# **A1 in Northumberland: Morpeth to Ellingham**

**Scheme Number: TR010059**

## **Appendix A Response to RR-04 Environment Agency**

<b>Regulation Reference:</b>	APFP Regulation Rule 8(1)(c)
<b>Planning Inspectorate Scheme Reference</b>	TR010059
<b>Application Document Reference</b>	TR010059/7.9.1
<b>Author:</b>	A1 in Northumberland: Morpeth to Ellingham Project Team, Highways England

Document Path: \\uk.wspgroup.com\central data\Projects\700380\A1 in Northumberland\02 WIP\01 EIA and flood risk\02 Drawing\Env Statements\ES Figures Rev P03\Figure 9.2 - HPI and Non-Stat Sites.mxd User Name: UKGDH001 Date Saved: 26/06/2020 10:39:39

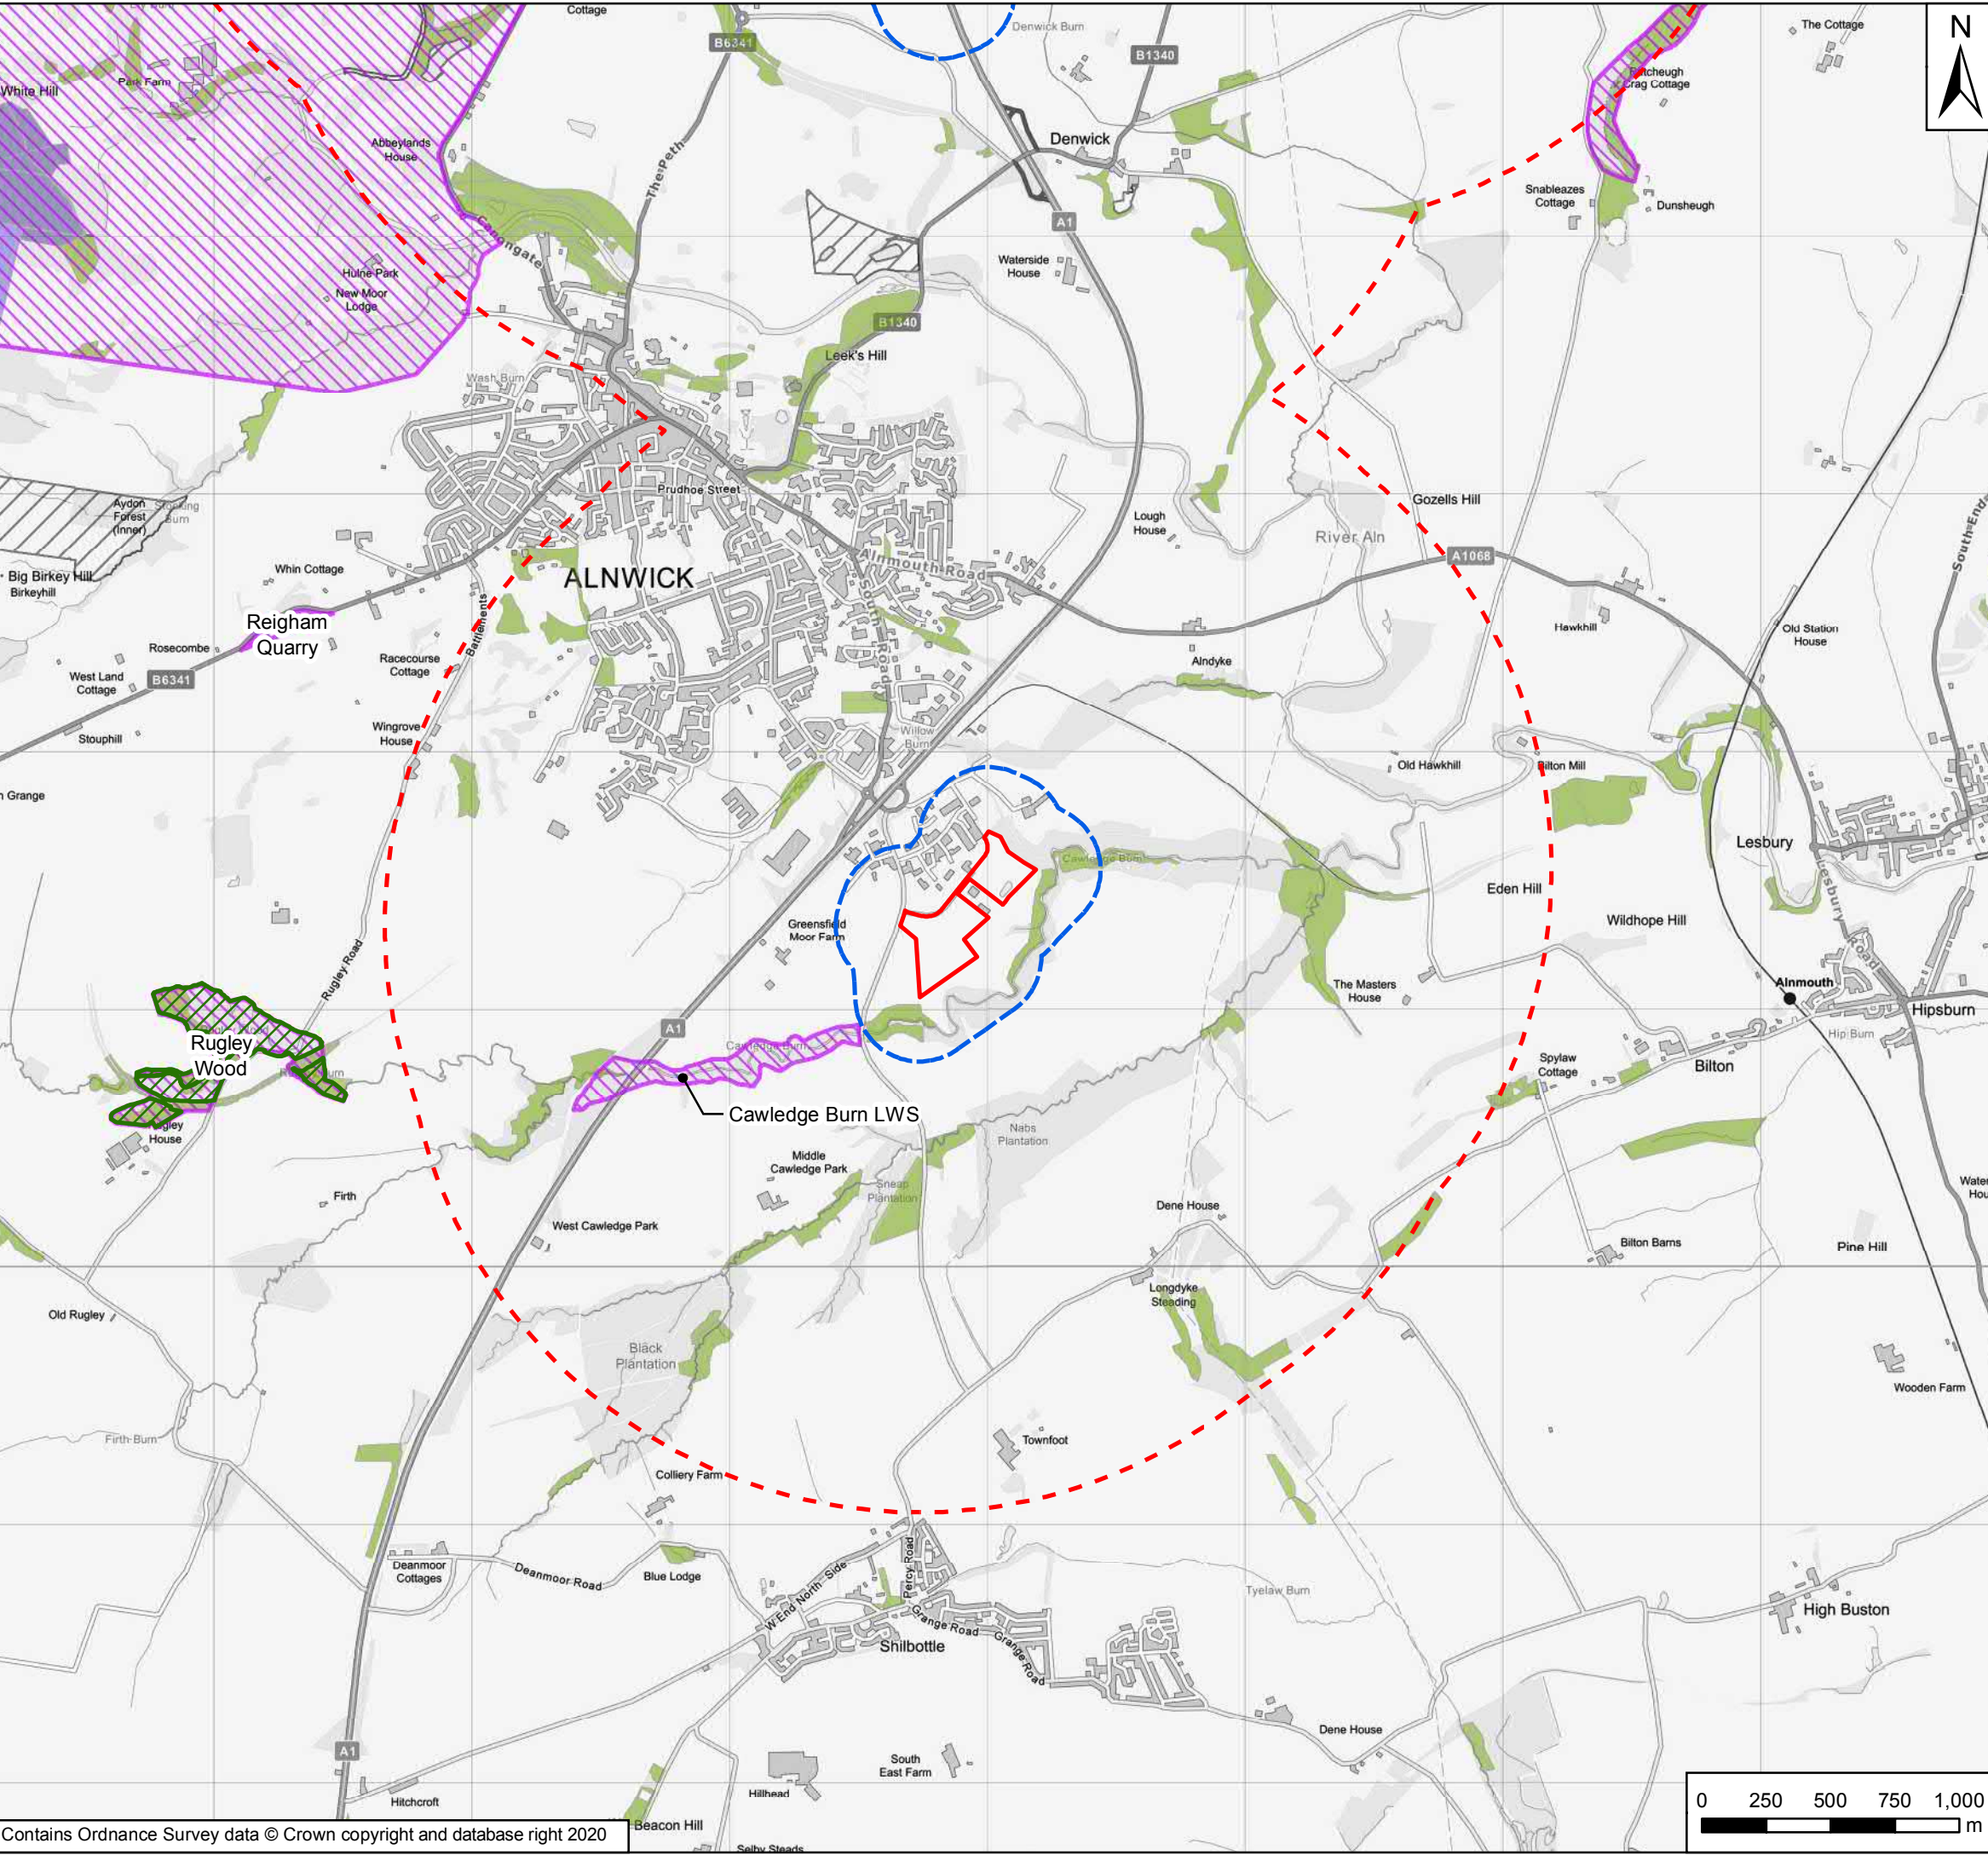
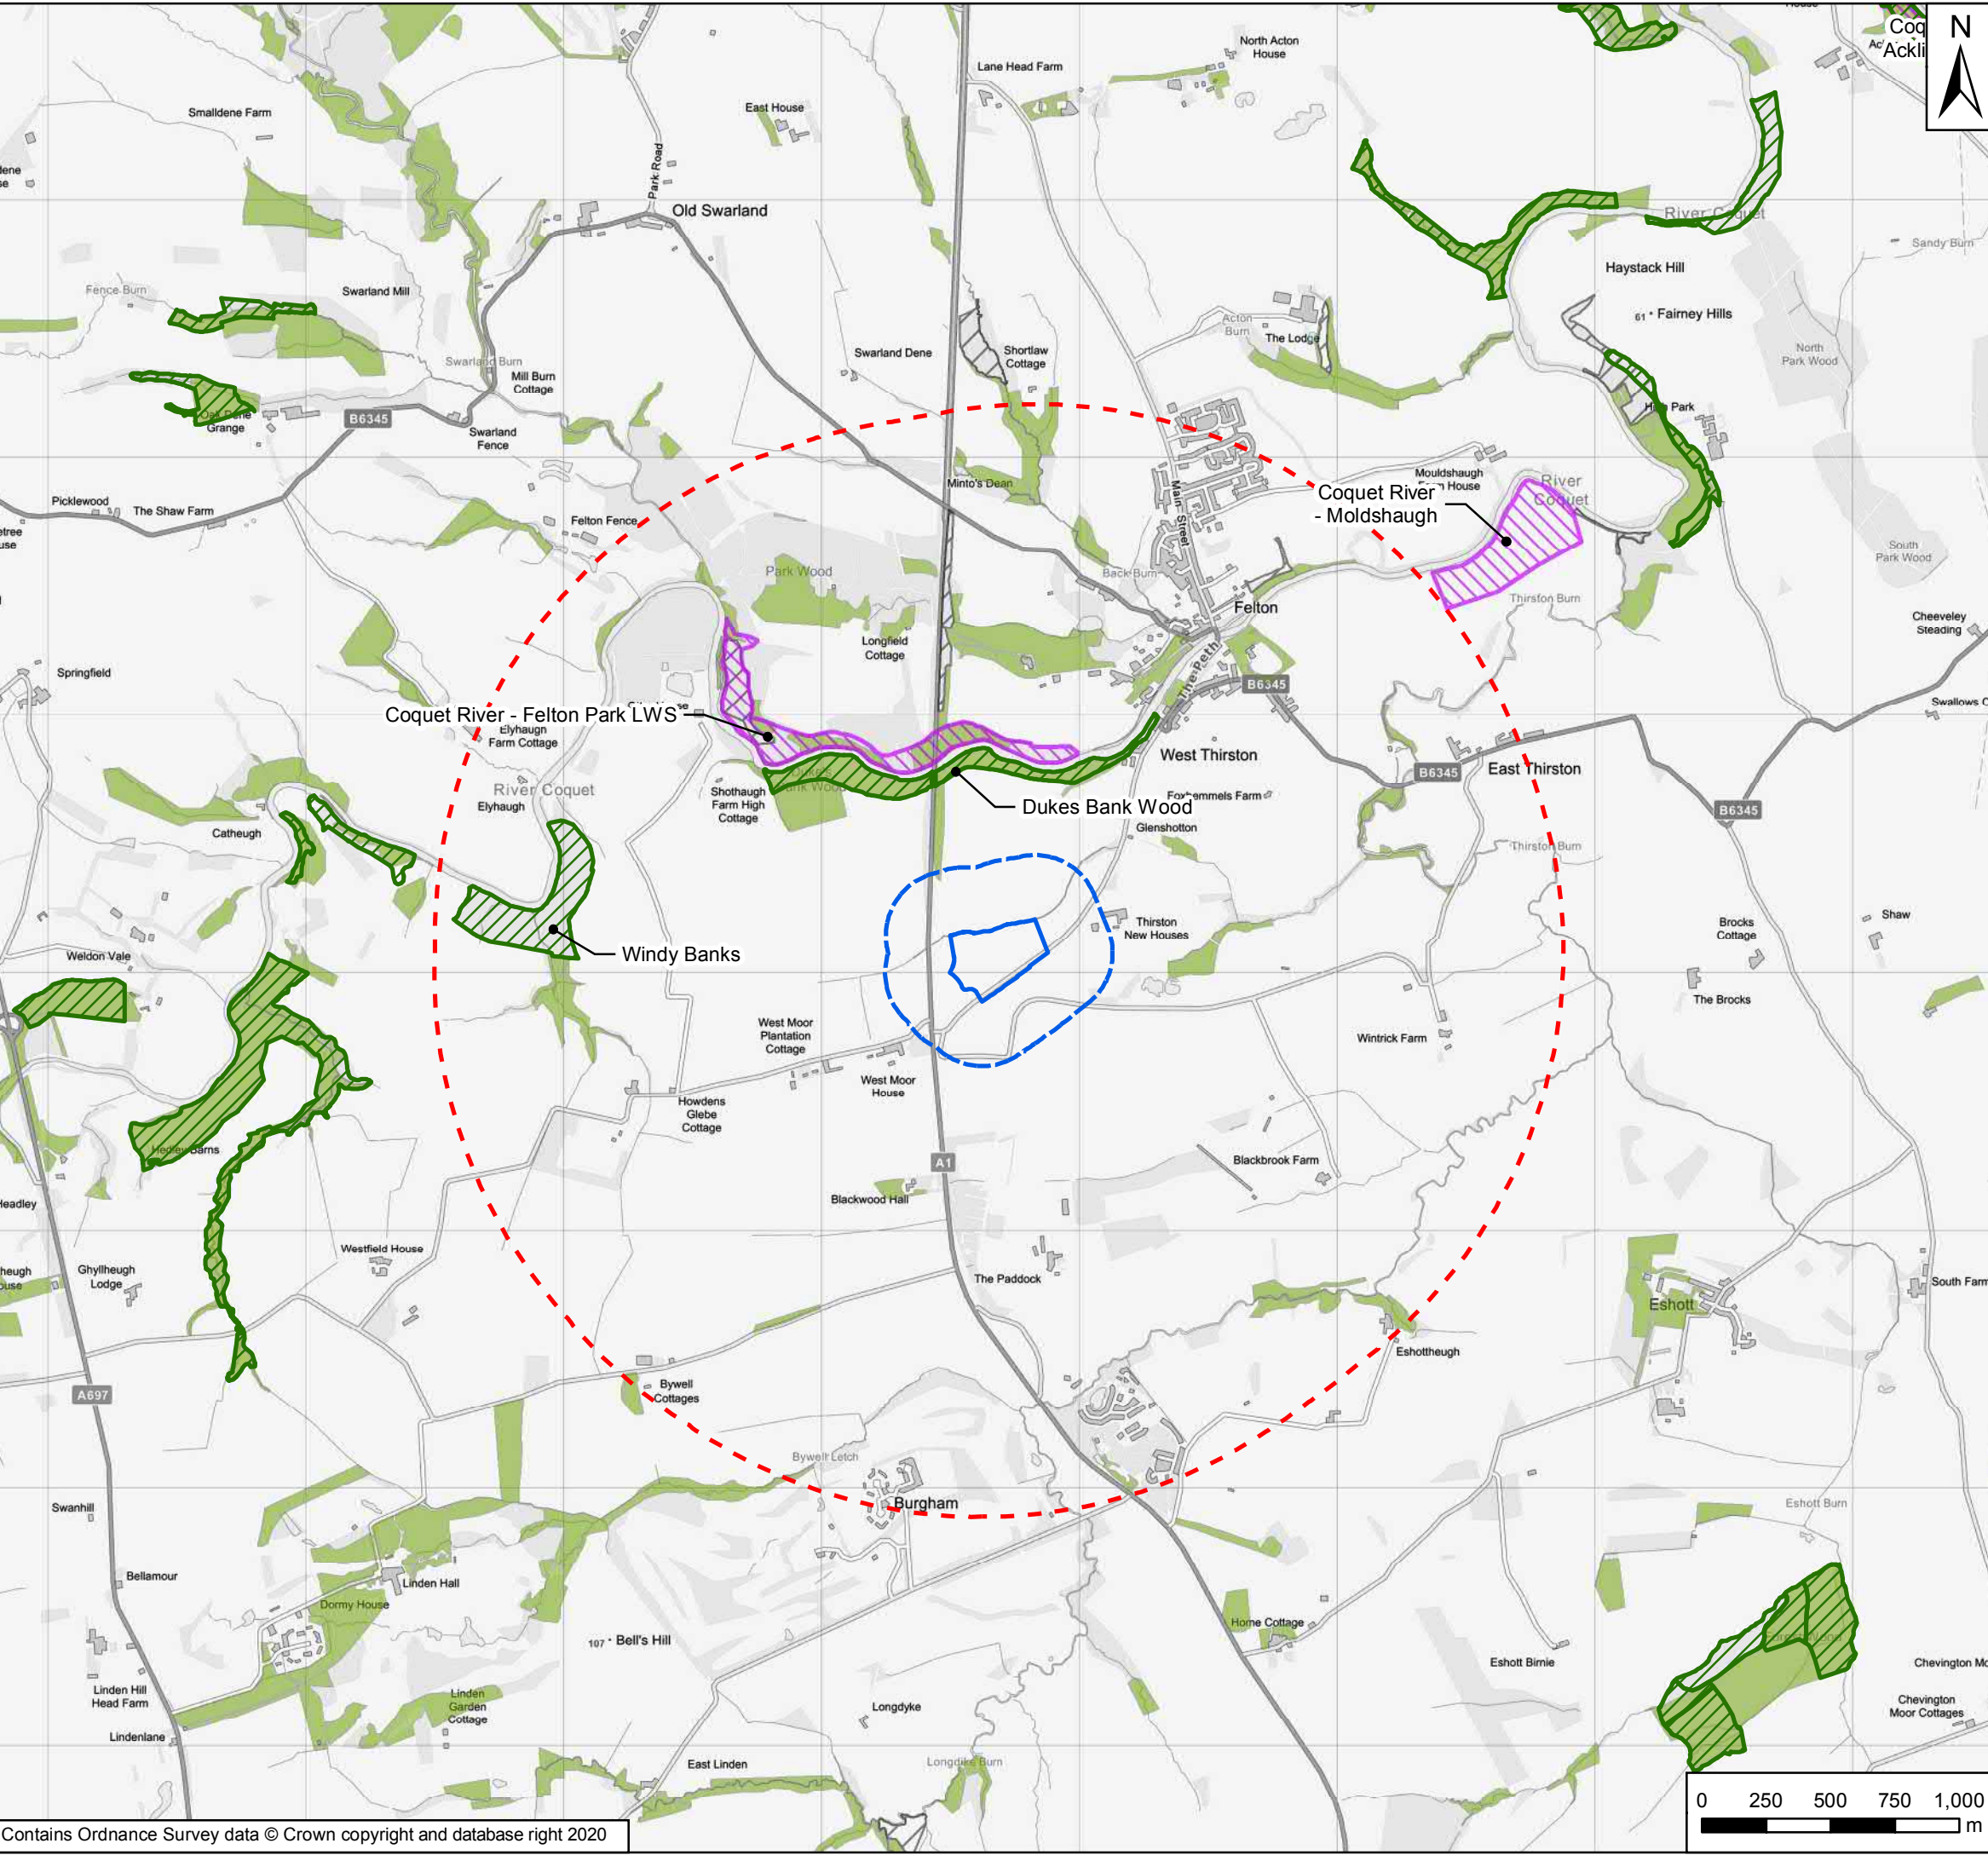
A.11 Habitats of Principle Importance: Issue and impact	Part A summarises a loss of approximately 200m of River Habitat of Principle Importance (HPI). This is not compliant with NPPF, which seeks to protect and enhance the environment. Stating that a 5% loss is not classed as a biodiversity net loss is not compliant with current best practice, as stated in our subsection; Biodiversity No Net Loss.	<p>A response regarding the definition of No Net Loss is detailed in A.4 above. Applying this definition, it follows that the assessment is appropriate.</p> <p>It is not considered viable to create new lengths of watercourse as this would rely on a water source to create the habitat. A water source cannot be created and therefore, in the absence of a natural source or diversion of water from an existing watercourse (which could have adverse effects on the existing water course and/or flood management), a watercourse cannot be readily created. As such, mitigation measures have been designed to address the net loss of approximately 200m of watercourse associated with Part A. These include improvements to approximately 850m of Longdike Burn (see EM047 of Chapter 9 Part A [APP-048] of the ES) and the design of new channels to increase their biodiversity value (see EM041 of Chapter 9 Part A [APP-048] of the ES). This would include the design of channels that are of greater biodiversity value than those lost to Part A of the Scheme.</p> <p>The BNNL assessment should be considered separately from the assessment detailed within Chapter 9: Biodiversity Part A [APP-048] and Part B [APP-049] of the ES. The Scheme is a NSIP and is therefore governed by the NPS NN rather than the NPPF. Therefore, there is currently no legal requirement to achieve no net loss or net gains in biodiversity. The BNNL calculations have been completed to inform the Applicant's internal requirement to achieve no net loss across all its schemes cumulatively (at a national scale). This is not linked to the Development Consent Order (DCO) process and is an internal requirement. The assessment has been undertaken as a best practice measure but does not represent a commitment to achieve no net loss for the Scheme. The Applicant is currently preparing a</p>

<p>A.13 Habitats of Principle Importance: Issue and impact</p>	<p>Culverting of watercourses drastically decreases their function, productivity and ecological value. This loss has been recognised in Chapter 10, section 10.10.31 where it states 'Overall, there is an increase in the total length of culverts and as a result there would be a permanent loss of natural channel associated with Part A along each of the watercourses in the Study Area'.</p>	<p>The Culvert Mitigation Summary (Annex A) submitted at Deadline 1 summarises the mitigation proposed for each watercourse crossing. Specific mitigation measures to maintain the function of the watercourse are discussed further below. The Scheme also maintains the hydraulic connectivity of all watercourses crossed by the Scheme to maintain downstream hydromorphological conditions.</p>
<p>A.14 Habitats of Principle Importance: Issue and impact</p>	<p>Any overall loss and impact will also require considerations in terms of the WFD. Furthermore, Chapter 9 section 9.8.9 states 'With regards to potential impacts to watercourses (running water – G2), excluding ditches, Part A would result in the direct, permanent loss of approximately 750 m of watercourse. Loss would occur to facilitate the construction/extension of culverts. This includes the loss of approximately 715 m of watercourses considered of Local importance and approximately 35 m of watercourse considered of National importance, Longdike Burn.'</p> <p>This is much greater than the 200m the ES summarises. It is assumed that the applicant has come to this conclusion due to the 540m of new channel due to be created as stated in section 9.9.6. However not only this is a net loss, but this is not a like for like replacement and channel realignments are unlikely to carry the same biodiversity value as previous channels. No designs for new channels have been submitted, and plans appear to show straightened channels, which provide a very low biodiversity value.</p>	<p>The reinstatement of new channel has been taken into account meaning that there is a net loss in Part A of c.200m. The assessment considered that the existing channels that are to be realigned are small watercourses that are already very straight and trapezoidal in shape, and with low ecological value and not identified to be suitable for fish. The proposed design of these sections of realigned channel would introduce features within the channel to provide greater variation to flow and habitat form. It is not considered appropriate to provide a meandering channel for these small features, particularly as this would be a significant change to the current channel form and not in proportion to the small nature of the watercourse. However whilst the realigned channel is straight, the proposals to include in-channel features will provide variation within the channel beyond that which is currently present which is considered more appropriate for the size of these features. The proposed in-channel features will be developed further during the detailed design in consultation with the EA and Local Authority, secured through requirement 8 of the DCO [App-014].</p> <p>The design for the crossing of the Longdike Burn comprises an extension to the existing bridge structure that will maintain the natural riverbed. A mammal ledge will also be added.</p>

Reference	Comment from Relevant Representation	Applicant's Response
		<p>Biodiversity No Net Loss Assessment in line with Defra Metric 2.0 for the Scheme. This will be submitted at Deadline 2.</p> <p>The 5% loss of watercourse for Part A is assigned as biodiversity no net loss in accordance with the response provided to question A.4. Within the assessment, no net loss has a range of 95-104% of the baseline in accordance with GN36. GN36 is currently the only published standard available.</p>
<p>A.12 Habitats of Principle Importance: Issue and impact</p>	<p>Considering Part A includes a new offline alignment with several new culverts and the extension of others within the online widening section and given this level of impact upon watercourses, the loss of only 200m (5%) of is not ecologically sound. No mitigation or compensation is offered for this loss.</p>	<p>As discussed in A.11 above, it is not considered viable to create new lengths of watercourse. As such, mitigation measures have been designed to address the net loss of approximately 200m of watercourse associated with Part A. These include improvements to approximately 850m of Longdike Burn (see EM047 of Chapter 9: Biodiversity Part A [APP-048] of the ES) and the design of new channels to increase their biodiversity value (see EM041 of Chapter 9: Biodiversity Part A [APP-048] of the ES). This would include the design of channels that are of greater biodiversity value than those lost to Part A of the Scheme.</p>
